From: Daun Johnson <Daun.Johnson@arun.gov.uk>
Sent: 10 August 2020 08:38
To: Planning.Responses <Planning.Responses@arun.gov.uk>
Cc: Juan Baeza <Juan.Baeza@arun.gov.uk>
Subject: FW: OBJECTION - AB/49/20/L

From: Emma Penn [REDACTED]
Sent: 09 August 2020 13:00
To: Juan Baeza <Juan.Baeza@arun.gov.uk>
Cc: Andrew Wood <Andrew.Wood@arun.gov.uk>; Planning <Planning@arun.gov.uk>
Subject: OBJECTION - AB/49/20/L

Following Martyn White's comments regarding destroying the further fabric of building, and the need for a full structural engineers assessment, it is noted that the current structural engineer report has made a fundamental incorrect assumption about the wall being continuous to roof level. It has already been knocked through at my level (2nd Floor) and also below me, and there has been no assessment to see if the necessary structural supports were added.

Proposed Ground Floor Plan
(Showing structure over)
(1:50)

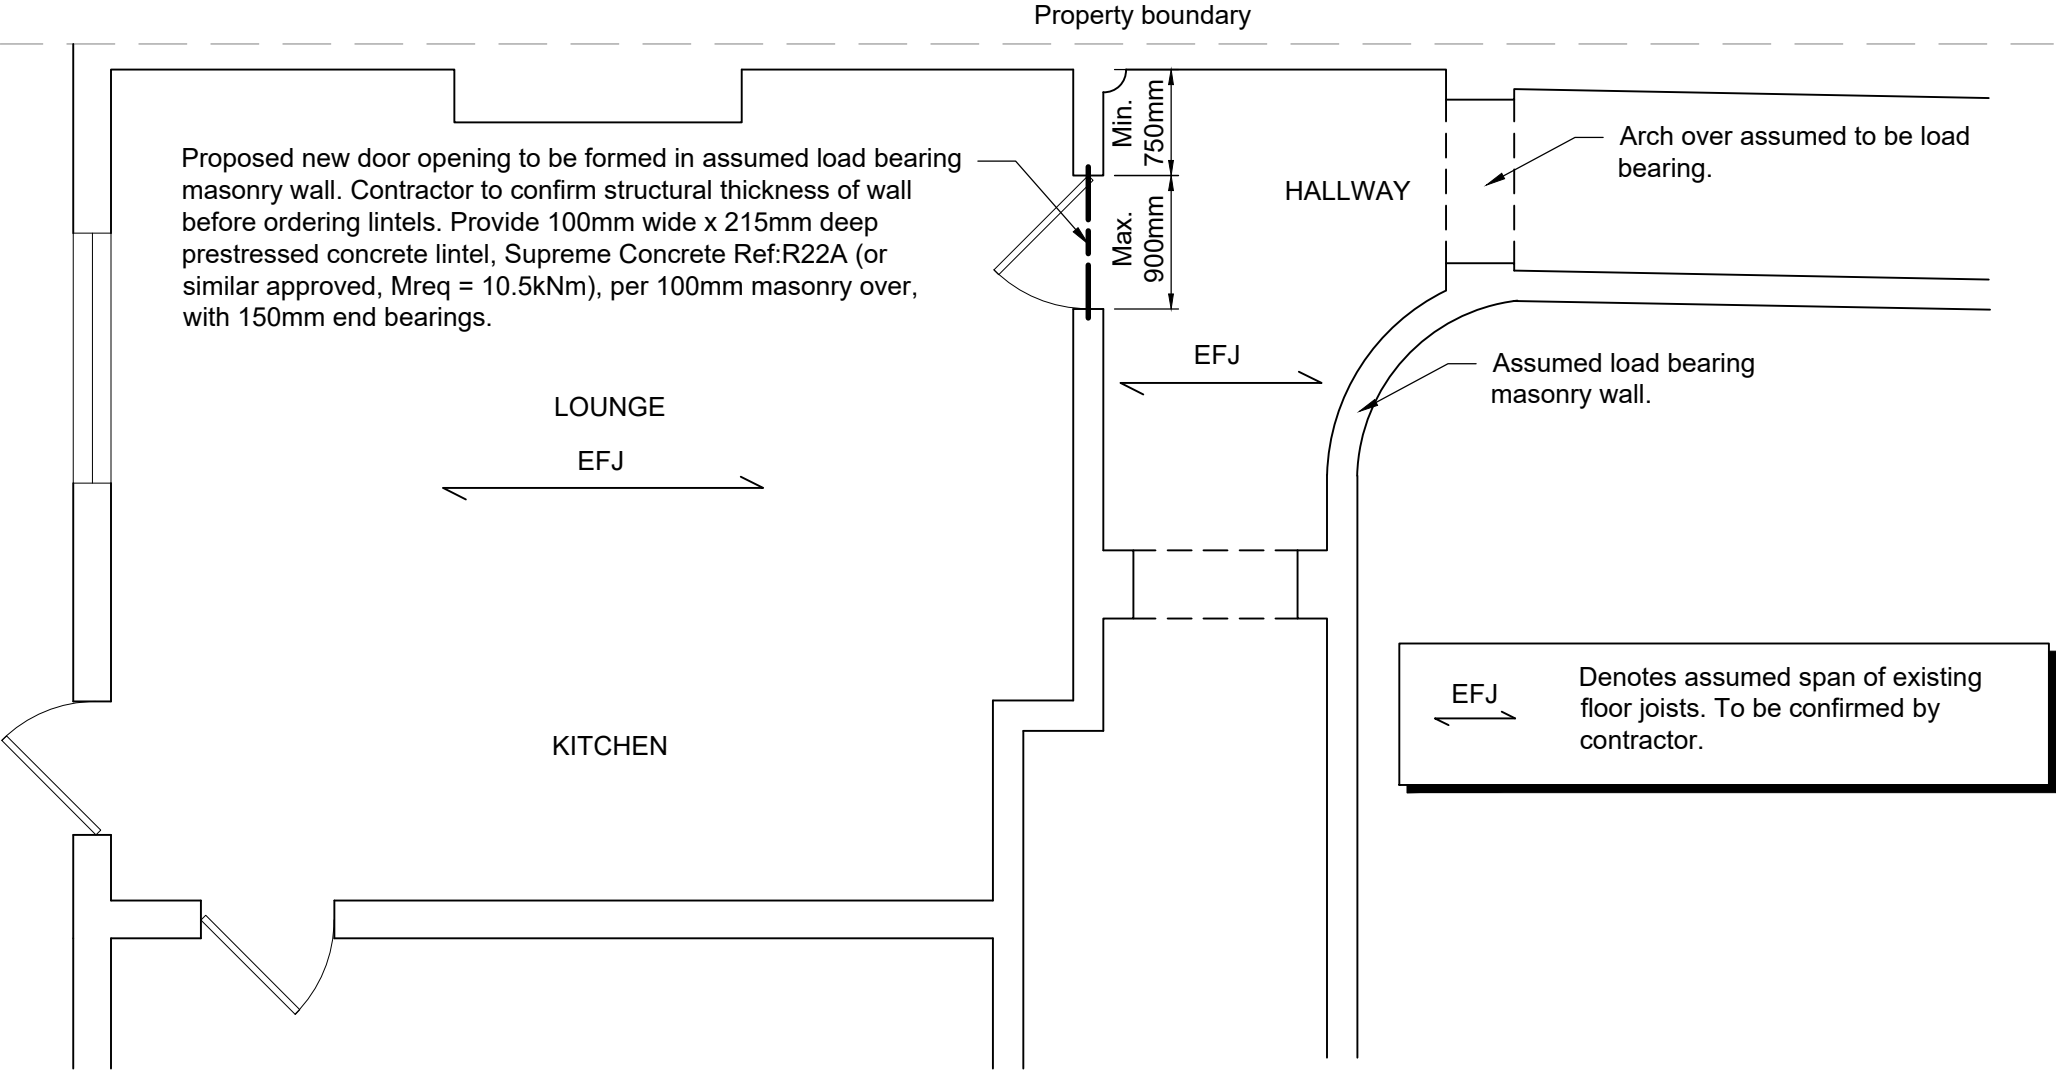
As it stands, no decision should be made until a structural engineer has properly assessed the matter.
